12 December 2023

Re: 35-75 Harrington Street, The Rocks (SSD-32766230)

Loss of Terrace Views – 46- 56 Gloucester Street The Rocks

Figure 90 existing view (above) and proposed view (below) from 46 Gloucester Street upper level balcony with proposed envelope (yellow outline) and detailed design (orange)

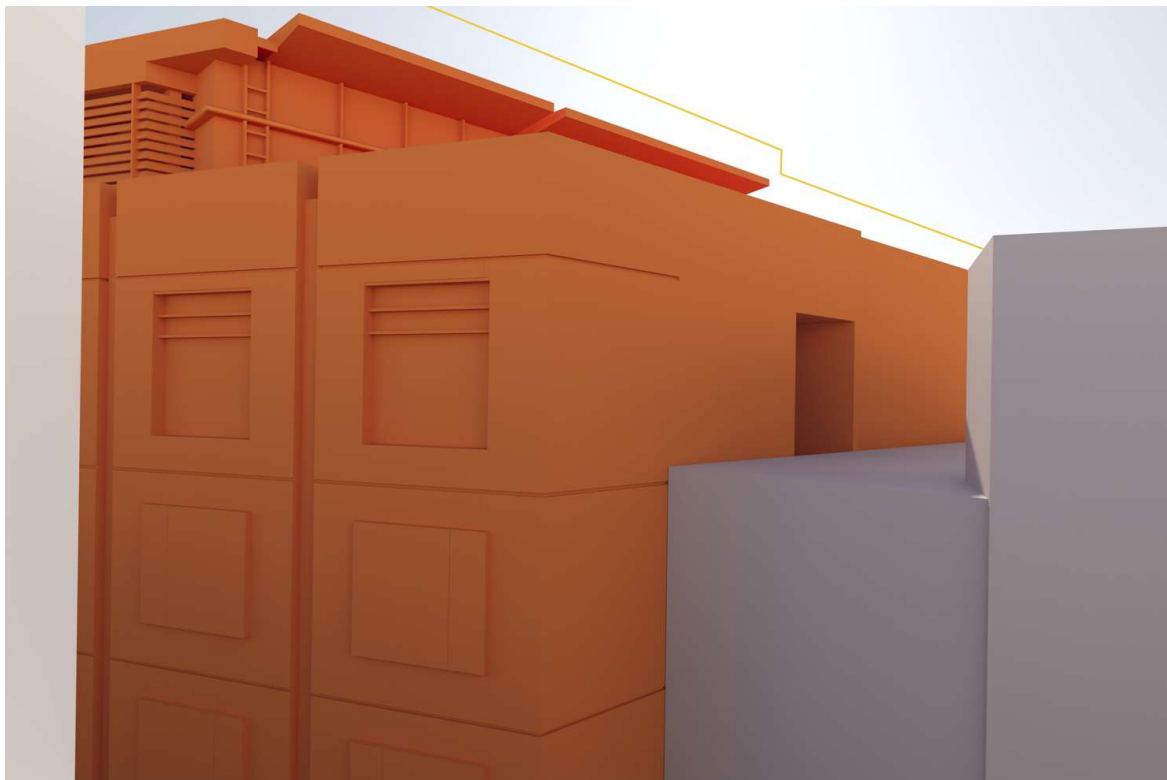
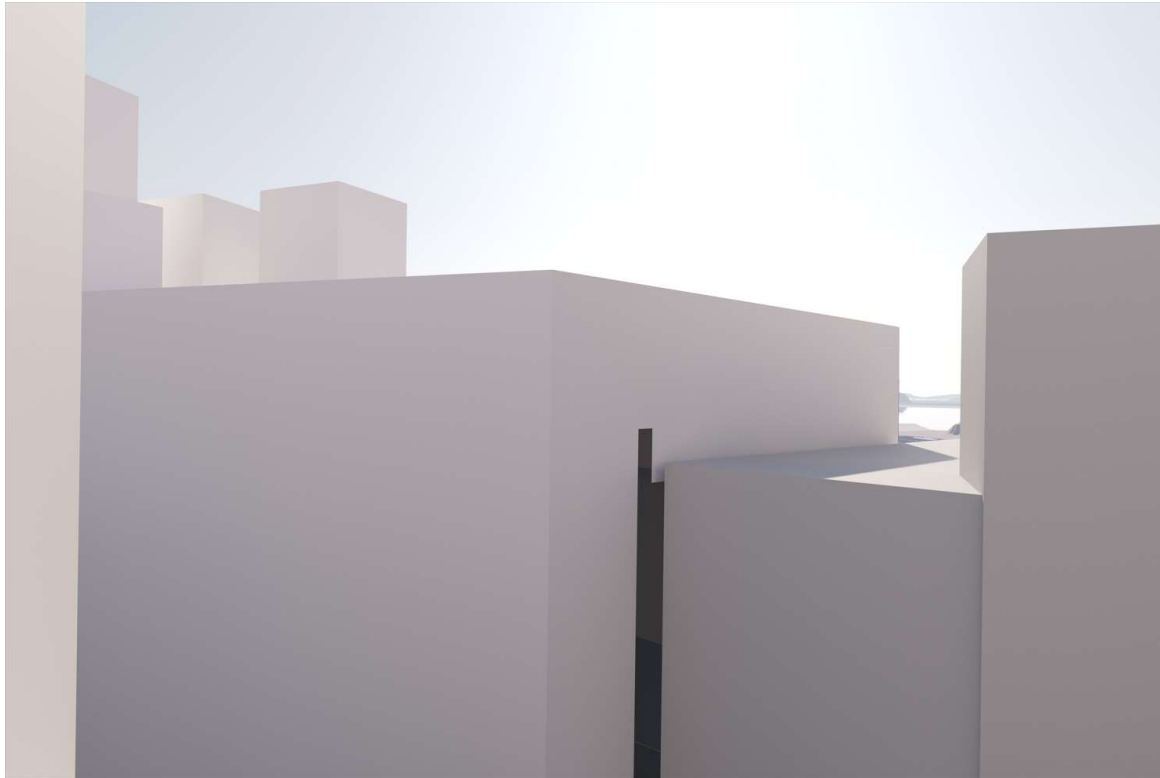
Reading the Urbis response it advises that an extensive Visual Impact Assessment has been undertaken for the project. There seems to be no reference to the effect on the views from any of the 46-56 Gloucester Street terraces, 46A Gloucester Street in particular, as it is closest to the proposed development. These terraces date back to 1914 and are historical residential property, backing on to Cambridge Street. I would consider that Urbis should have to include any views from these terraces in any Visual Impact Assessment.

The historical Gloucester Street terraces which all back onto Cambridge Street, particularly those towards the Argyle Cut end of the row, should have been included in any Visual Impact Assessment. This would allow the investigation of any impact on view lines from terrace balconies, due to this development and any impacts, from its height breaches of the established SCRA envelope.
